DEPARTMENT OF PARKS AND COMMUNITY SERVICES

May 30, 2024

Subject: Thompson Thrift Apartments Rezone Review (P-24-007)

REZONE MAP EXHIBIT

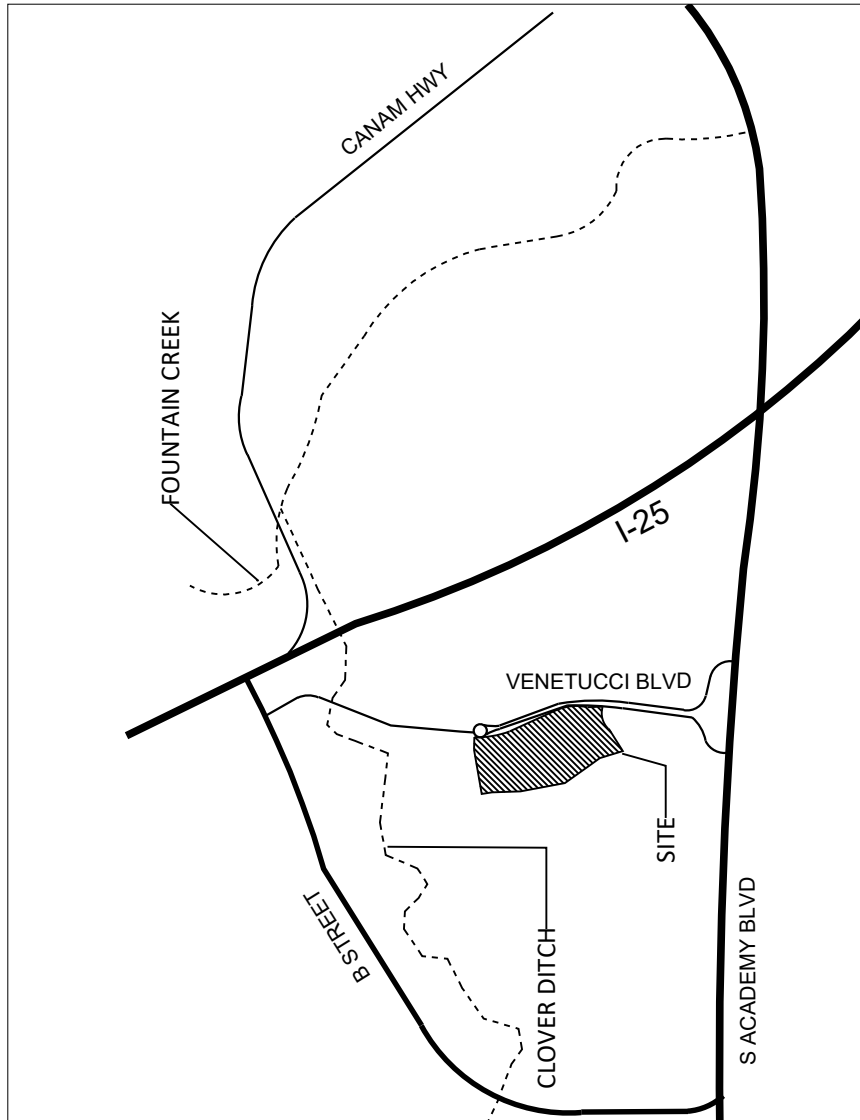
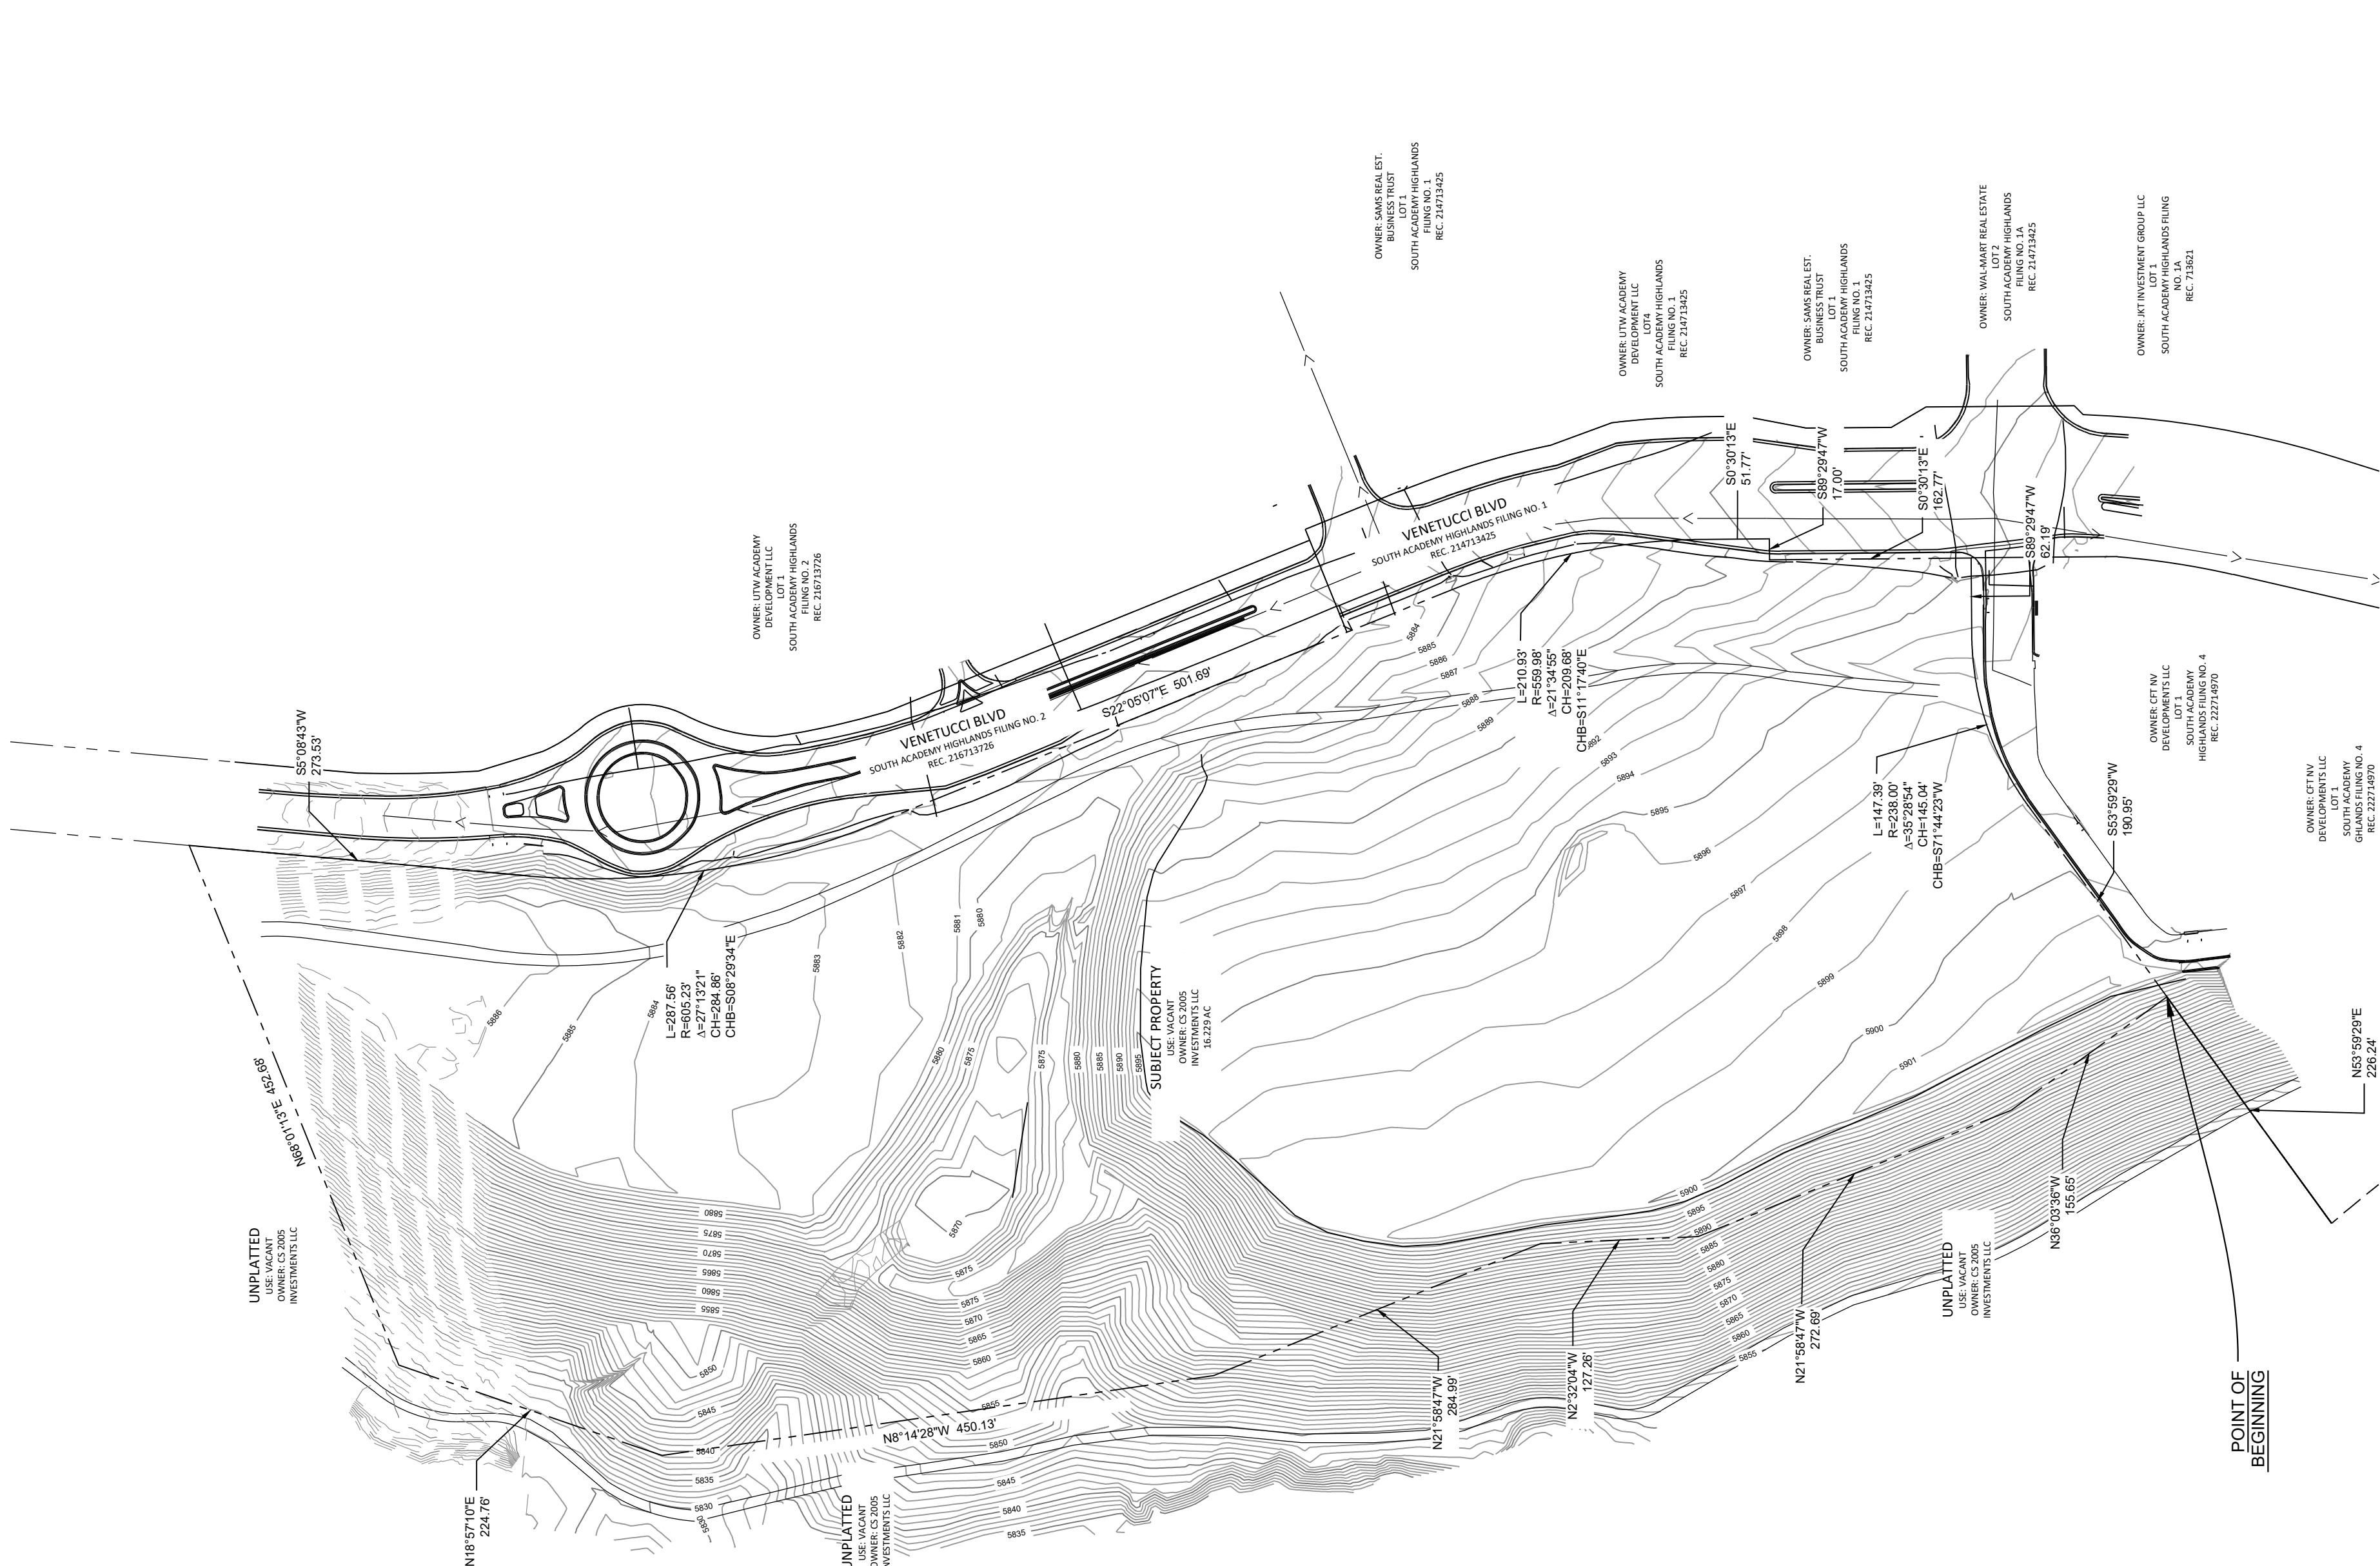
The 2022 El Paso County Parks Master Plan shows a **possible** impact to the B Street Secondary Regional Trail, which runs north-south along the western boundary of the overall parent parcel (Schedule #6504300049), as shown on the attached map. Although this rezone application is only affecting a 15.43-acre portion of the overall 62-acre parcel, trail easement requests are generally tied to the parcel and not the site plan. If this zoning application creates a new parcel encompassing the apartment site, no trail easement will be necessary until the surrounding parent parcel is developed in the future. Staff anticipates that this will be clarified with future submittals of preliminary plan and final plat applications.

However, if the parent parcel remains unchanged, then El Paso County Parks and Community Services will request a 25-foot trail easement for the planning, construction, maintenance, and public access of the B-Street Secondary Regional Trail. The location of the trail, as shown on the South Academy Station PUD Plan in the applicant's Letter of Intent, is acceptable to EPC Parks staff, as it generally follows the original master planned alignment.
